Sent: 10 June 2019 20:16
To: Anita Gardner
Cc: WALKER Fiona OBS/S EUR
Subject: Case: LU/126/19/PL Development of 25 River Road
Importance: High

Ref: Case: LU/126/19/PL Development of 25 River Road

PROPOSED DRAWINGS:
Terminus Place
Proposed & Existing Street Scenes

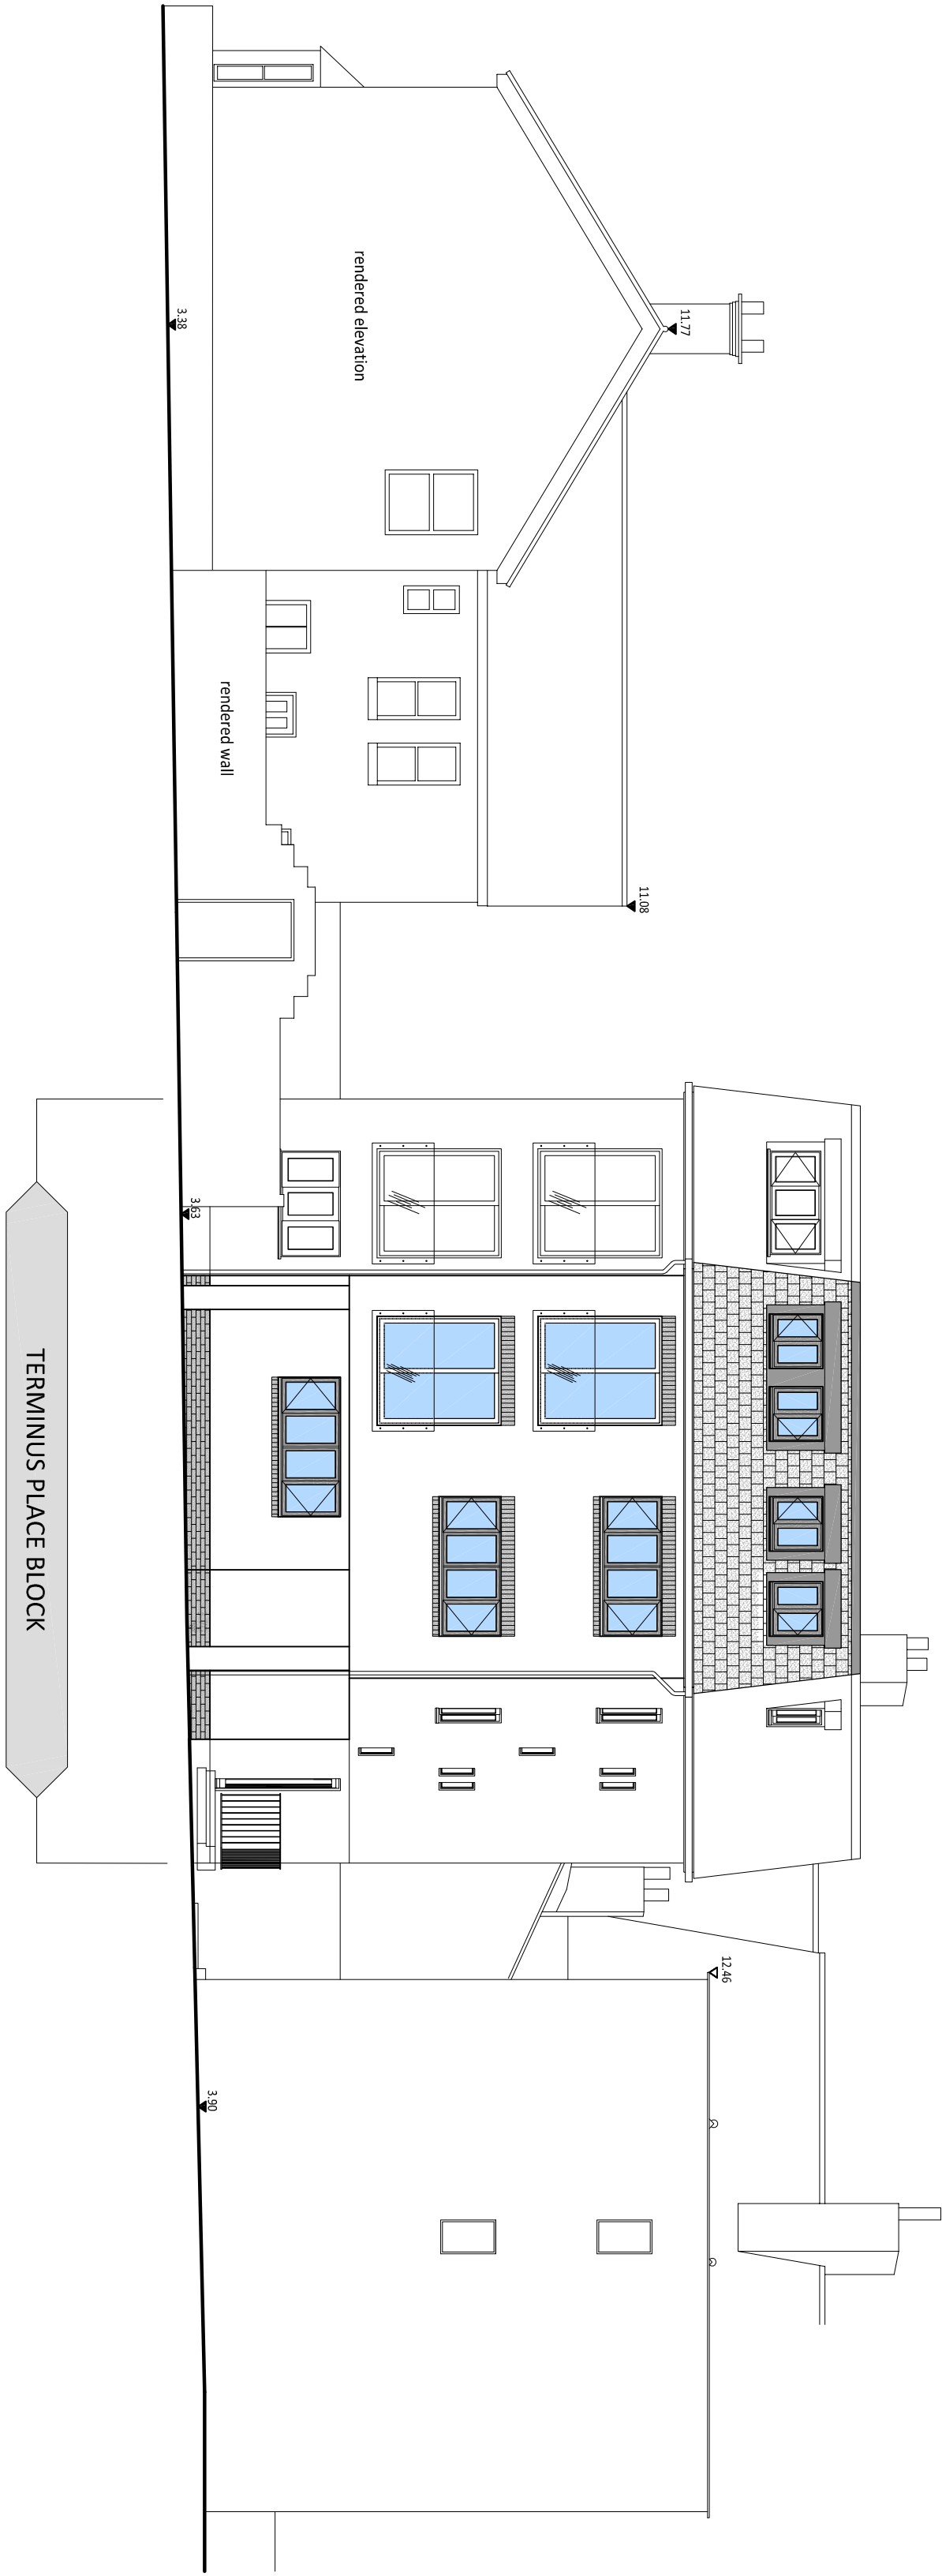
1. The current property has not been used commercially since January 2014. If allowed to proceed with the ground floor parking this would cause potentially high levels of noise pollution especially to the basement bedroom in Flat 1.
2. The frontage on River Road is not in keeping with the current dwellings of Albion Terrace and Cyprus Villas. It is too high. It also looks that the River Road block extends beyond the building line of the properties in Albion Terrace.
